Application no: 23/01496/DISC

Location: Proposed Himley Village North West Bicester, Middleton Stoney Road, Bicester

Transport Development Control

My comments focus on Chapter 6 of the Design Code – Access and Movement Codes

DRAFT
Framework Plan
Himley Village
Bicester

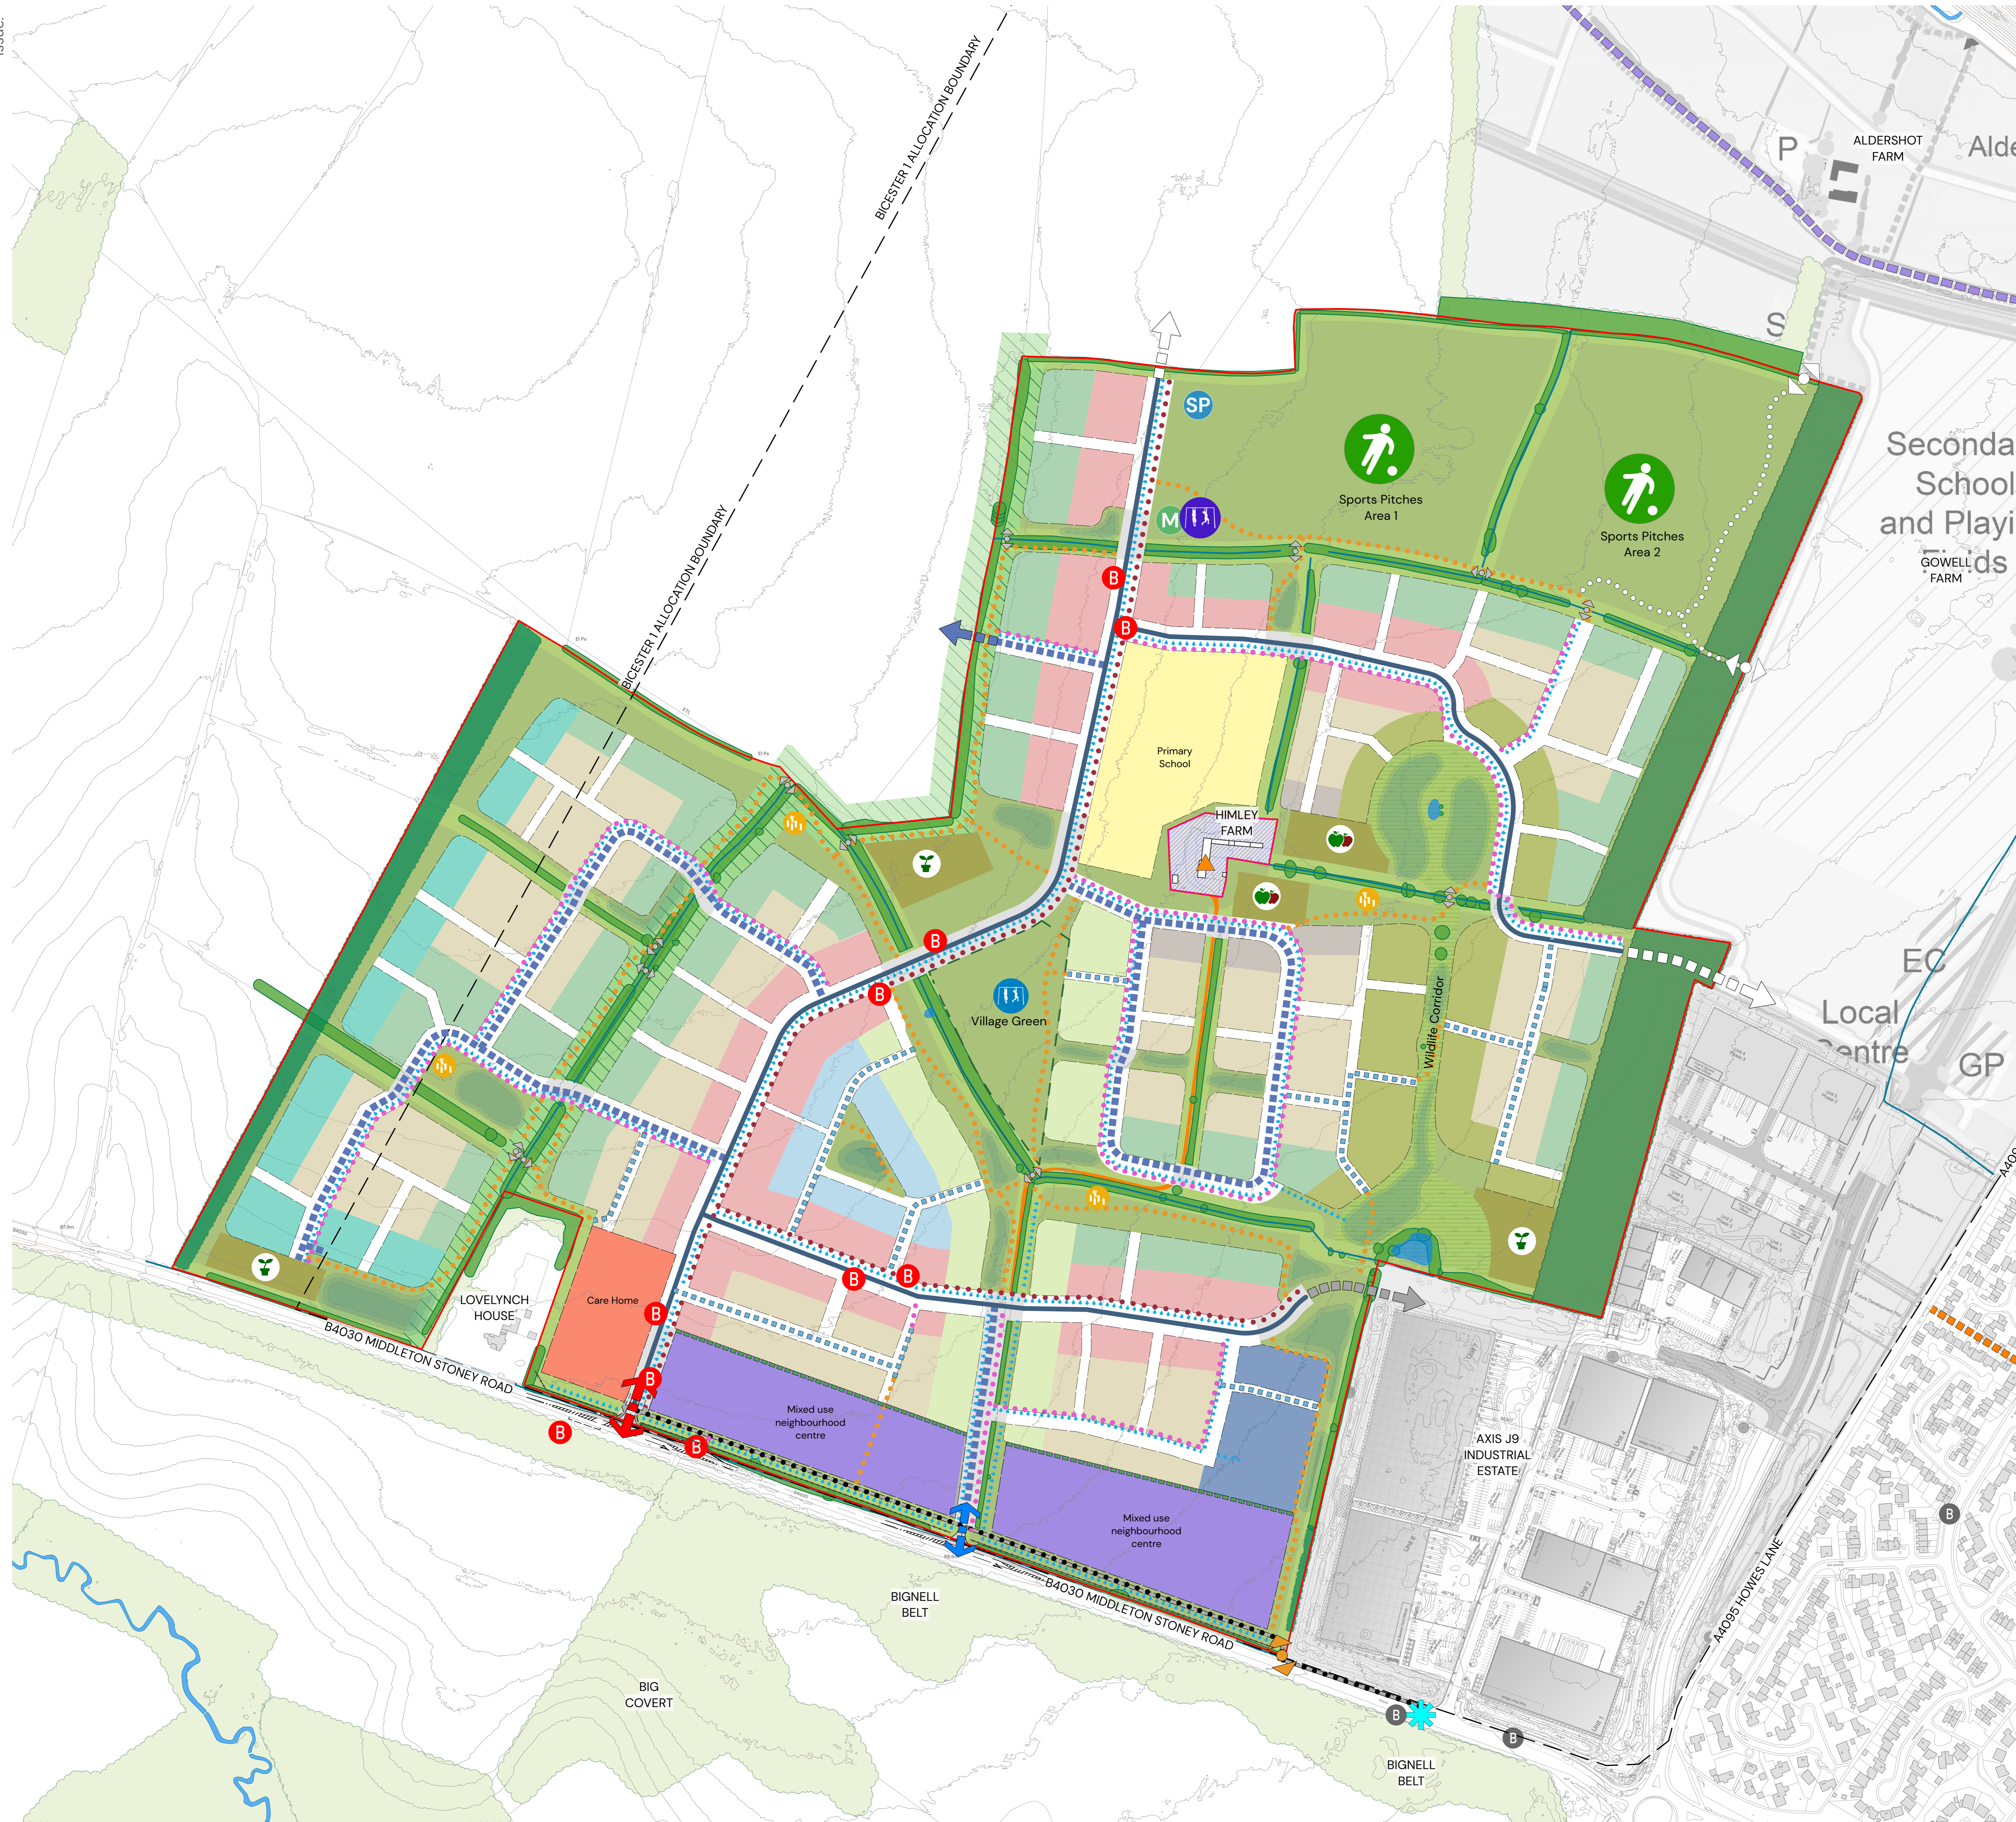
LTN 1/20 guidance is that routes for cycles and pedestrians should preferably be more direct than for motor vehicles (filtered permeability). This element of the Framework Plan could be improved, particularly in the north of the site, where motor vehicle permeability could be reduced.

6.20-6.12 Vehicular access points 1 to 5 are as agreed in the outline permission, though it should be noted that point 3 is to be bus, pedestrian and cycle access only. Access points 3-5 are listed as 'potential' but they are required to be provided by trigger points as set out in the S106 agreement. This should be referenced here.

Public transport strategy: The bus stop locations are as agreed. For the early phases, beyond 400 dwellings, there will need to be a facility for the bus to enter the site and turn round, so provision should be made for a temporary turning head. This should be indicated on the plans.
